# Briefing Note

Our Reference: 24278.99481  
 Revision # - 0  
 Date: 18<sup>th</sup> March 2019

## ‘Response to Submissions’ - Project 24278

A Statement of Environmental Effects (SEE) was lodged with the Department of Planning and Environment (DoPE) on the 22<sup>nd</sup> of January 2019 as part of the application for modification to Approval (DA 05\_0080) for De Bortoli Wines (DBW), Bilbul. On receipt DoPE arranged for notification of the modification application with the relevant agencies, allowing for them to respond to the application.

Figure 6 Current irrigation area

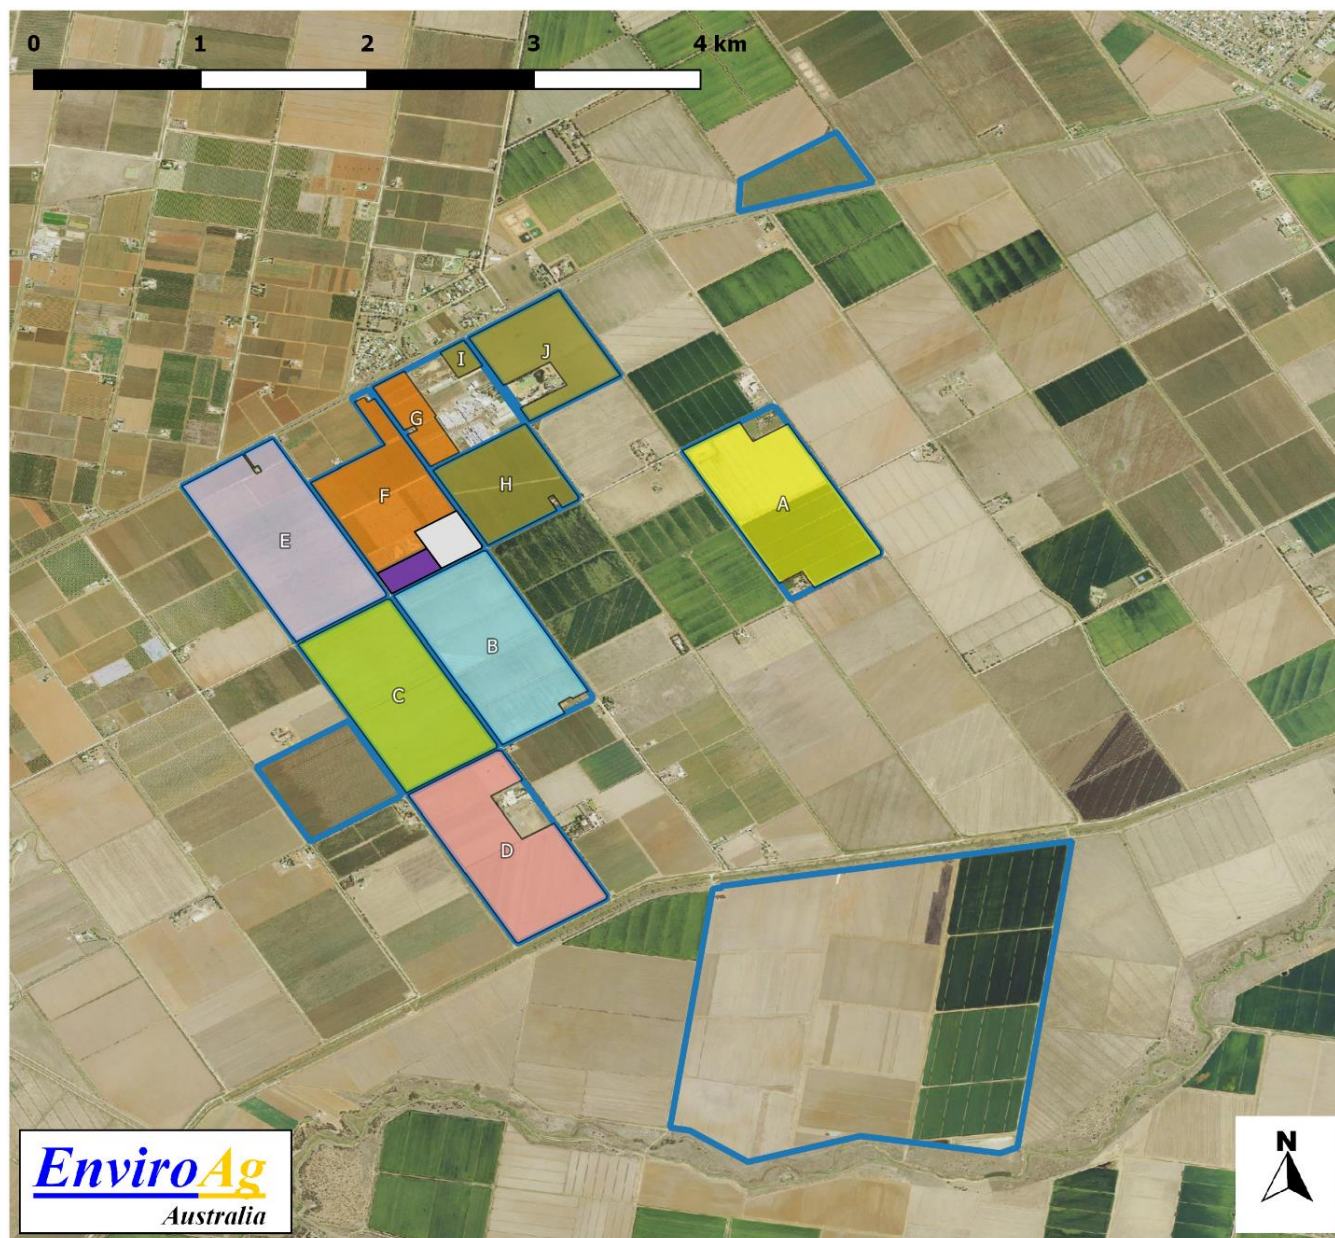
Where existing unauthorised buildings, not approved as part of any previous development application, must be identified on the plans and that application be made for a building certificate where required.

Existing unauthorised buildings are identified on plans (Refer to the SEE, Figure 6, page 23).

DBW will make application for a building certificate where required.

Figure 9 Additional Infrastructure Concept Plan

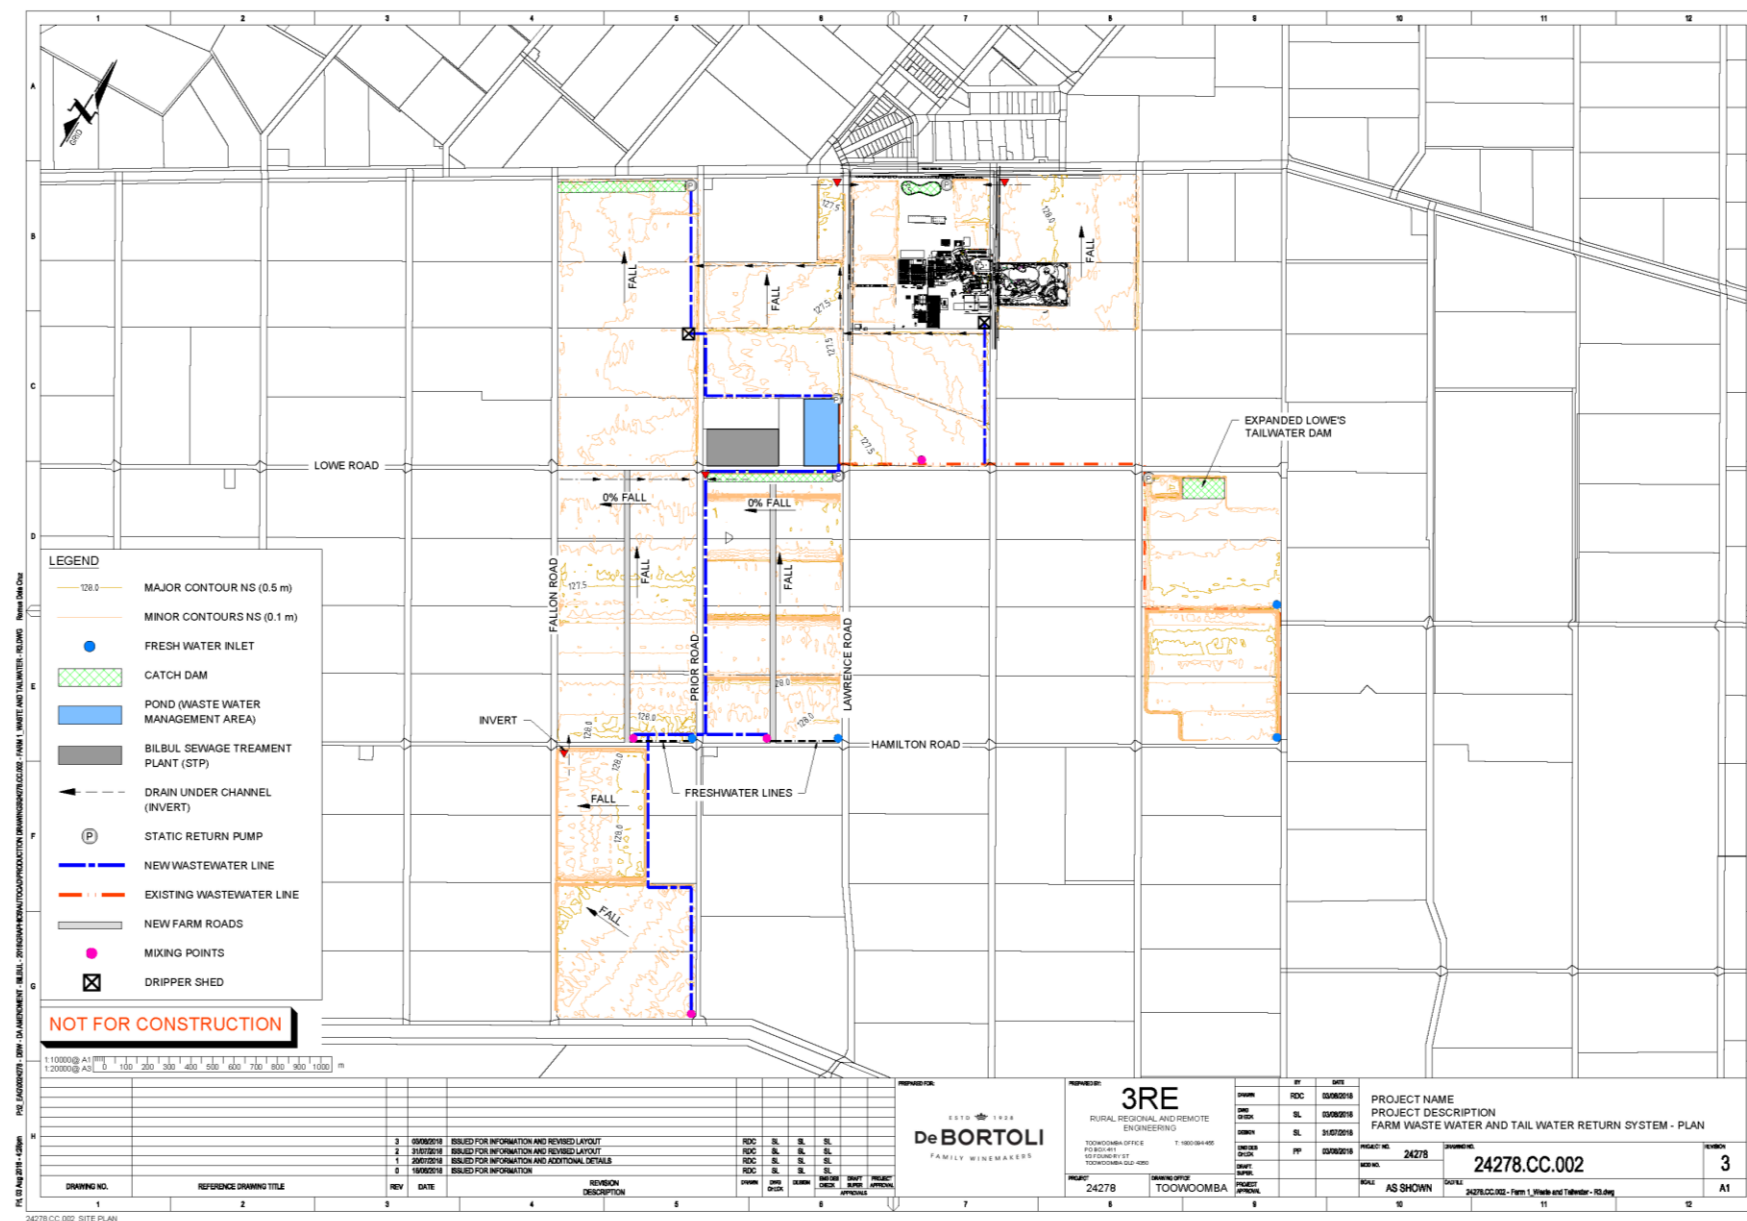
Details including plans showing lot boundaries are to be provided as to how waste water will be directed to these allotments. Waste water pipelines are to be located within the property boundaries. Where these pipelines cross through or under Council road reserves and or Crown or MI reserves, land owner's consent is required. Where the pipelines, pumps and other associated infrastructure rely on Council owned or managed land, including within the road reserve the proponent will be required to enter into a lease agreement.

Detailed plans, showing lot boundaries are provided in Figure 9 of the SEE on page 29. Lot/Plan labels were not included as this would have overcomplicated the plan; however a detailed description of the required works, including lot numbers, is included in Table 11 of the SEE.

As stated on page 28 (Section 4.2.3) of the SEE, the majority of the required works are within private land owned by DBW. As with the works completed for the original Waste Water Utilisation Area (WWUA), any works conducted outside of DBW land will be conducted with prior consent, and if required, lease agreements.

At this time the proposed work includes a total of two (2) locations where pipework would cross Crown or MI lands, and four (4) inverts, as indicated in Table 11 of the SEE. A summary of these crossings, including the lots they are linking is shown below in Table 2.
